Whalley Parish Council

Planning Application 3/2012/0022
3 Springfield Close Whalley

Drawing Title
Proposals

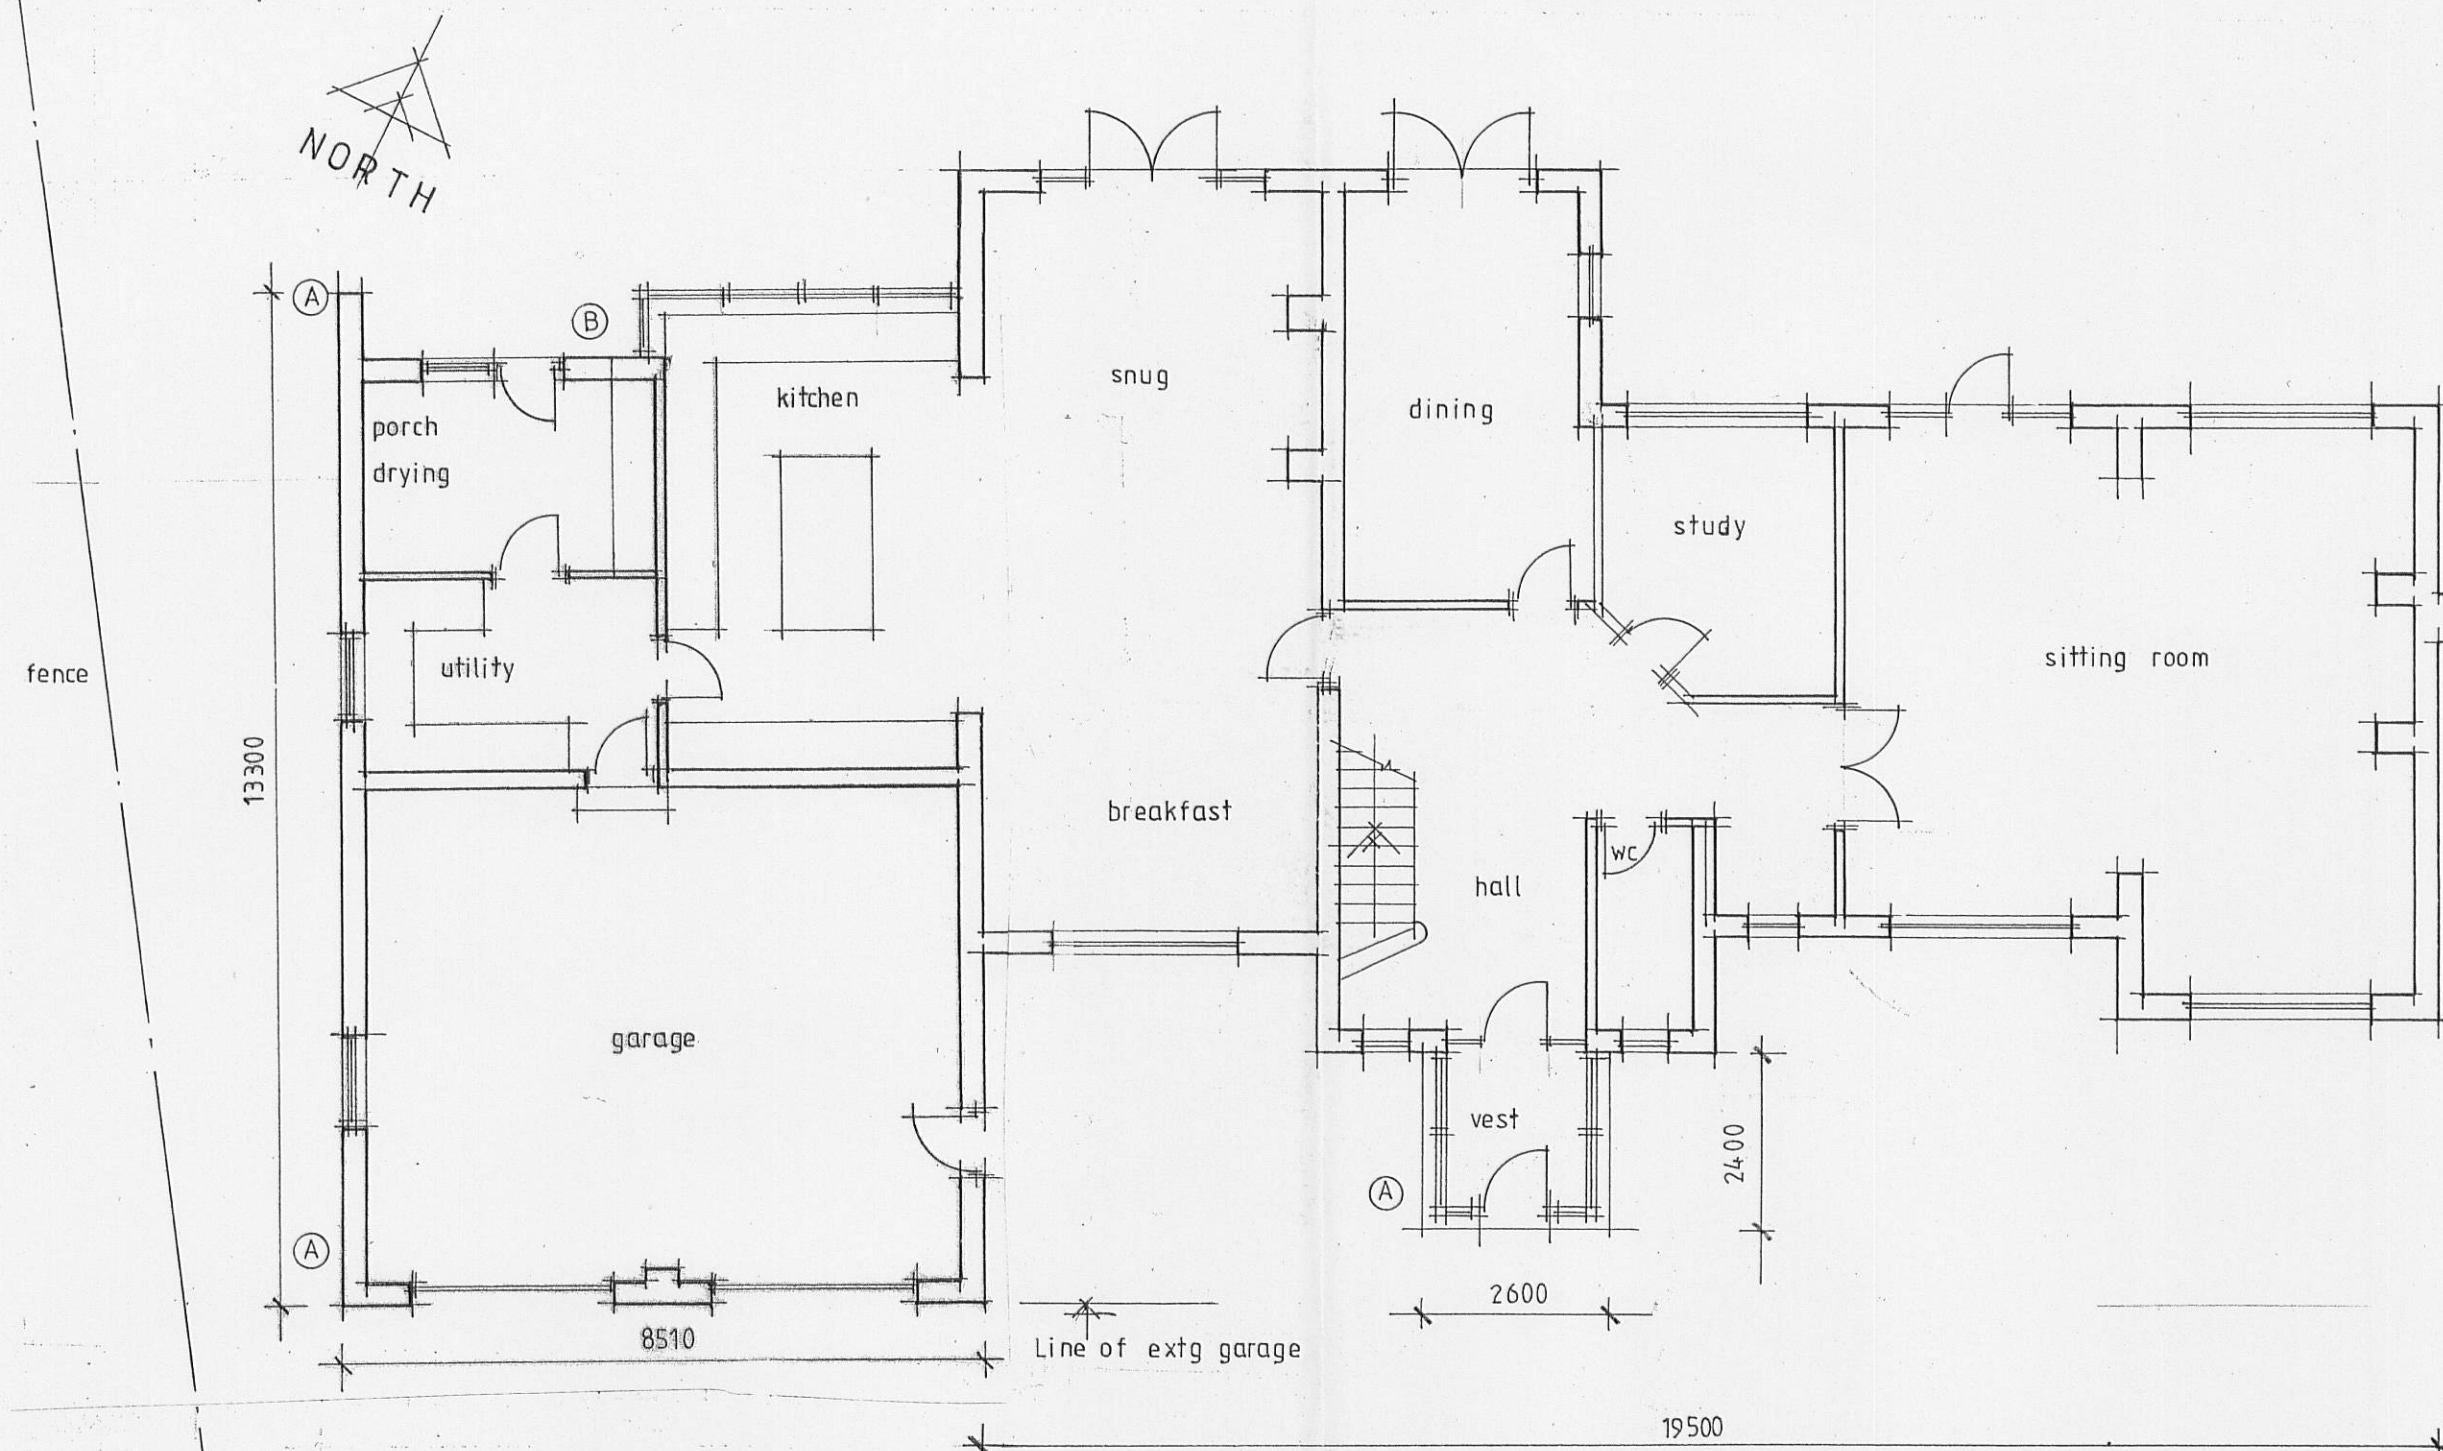
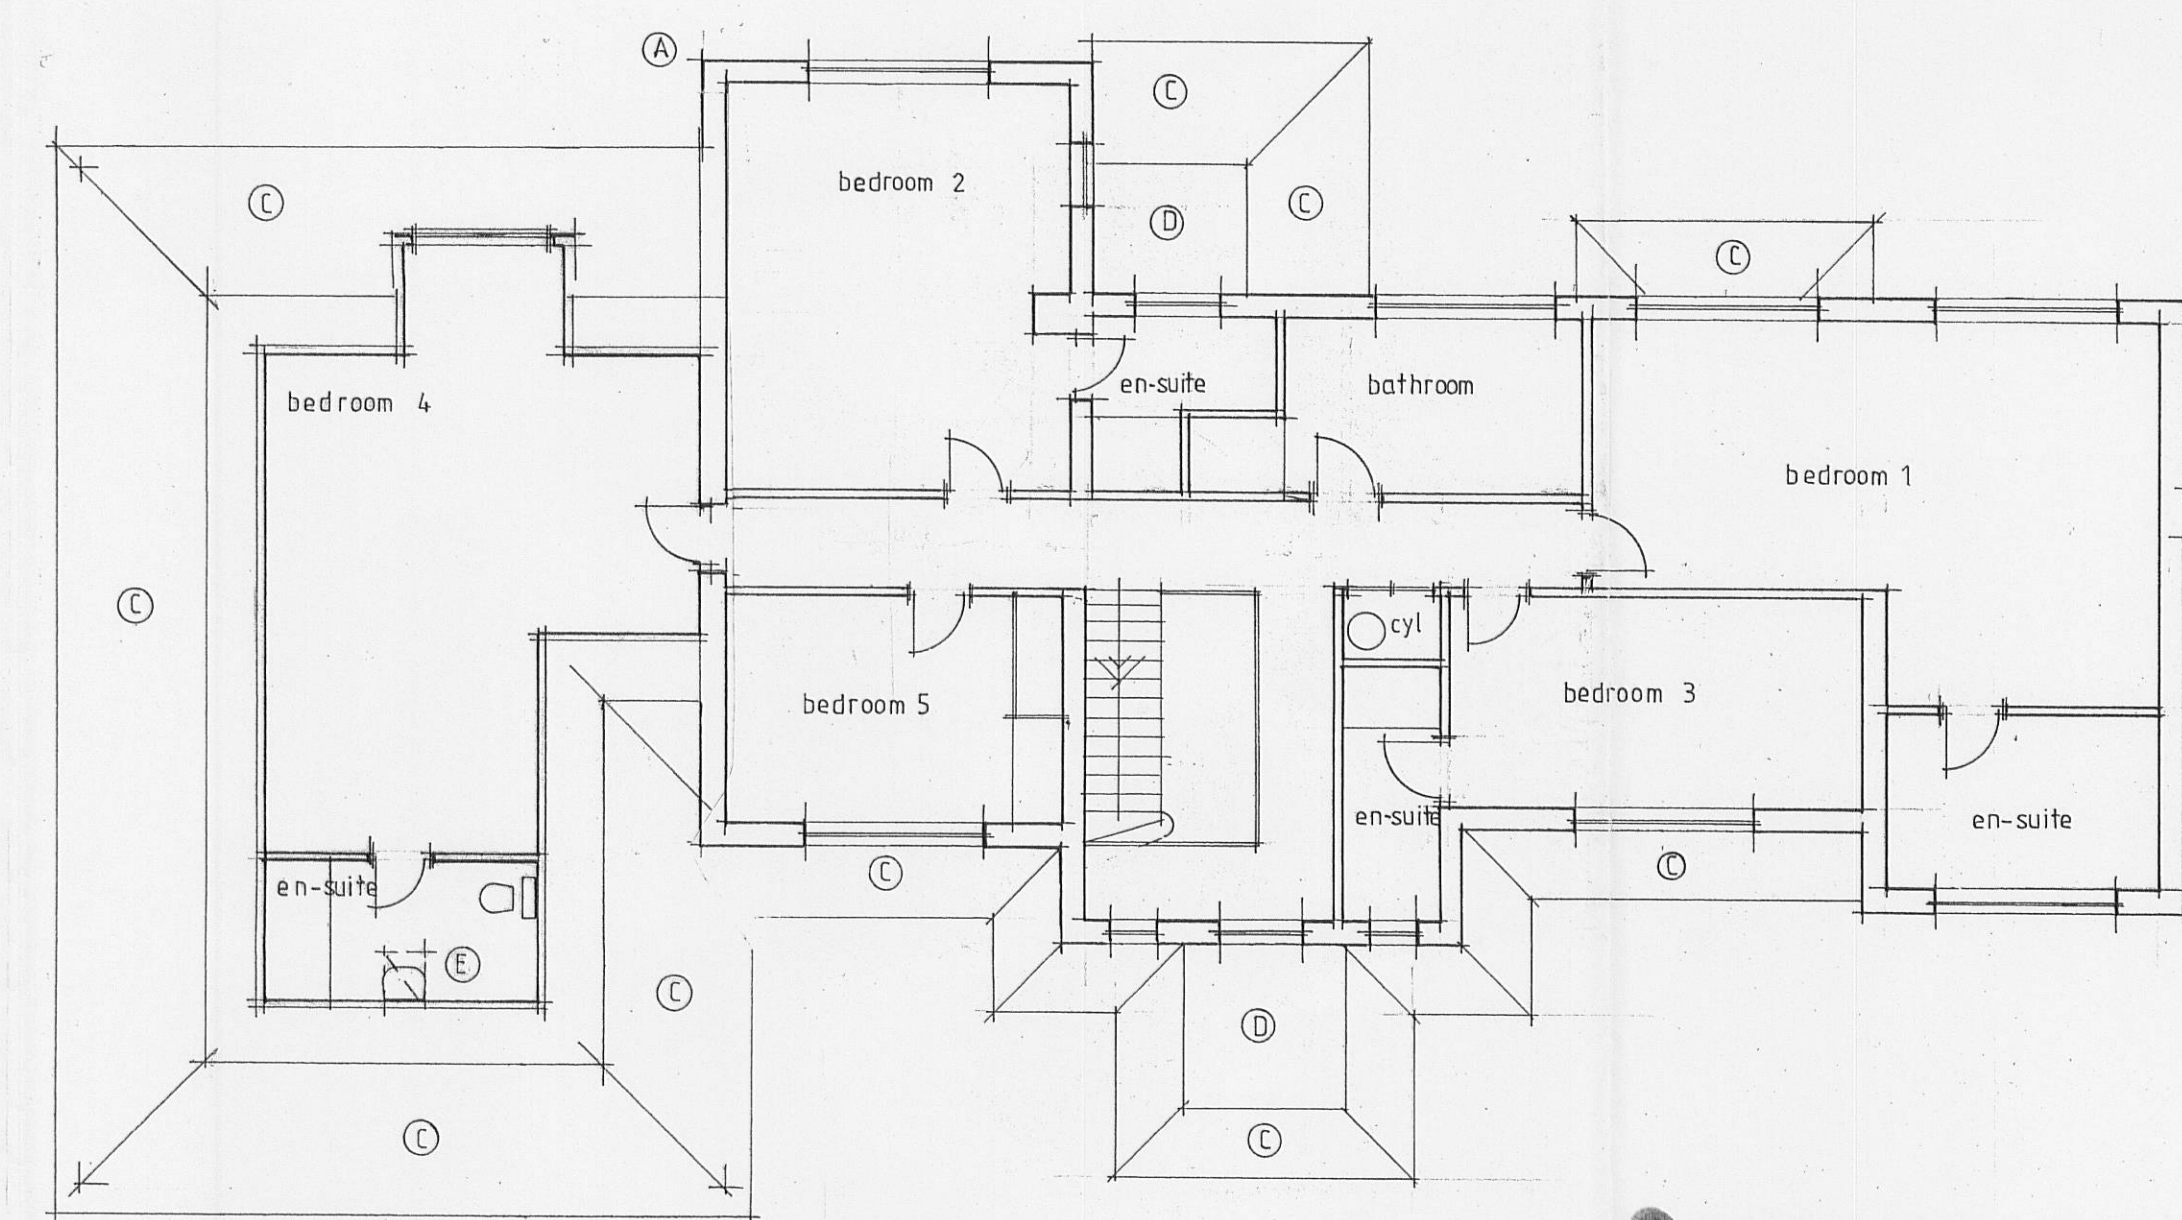
The Parish Council, whilst not objecting, observe that the increased height of the amended proposal, particularly above the garage, is likely to create a substantial continuous development which will dominate the street scene at the northern end of Springfield Close. Careful consideration needs to be given to this application, preferably by inspection by members of the committee or at least by the officer concerned to assess the impact of the amendment,
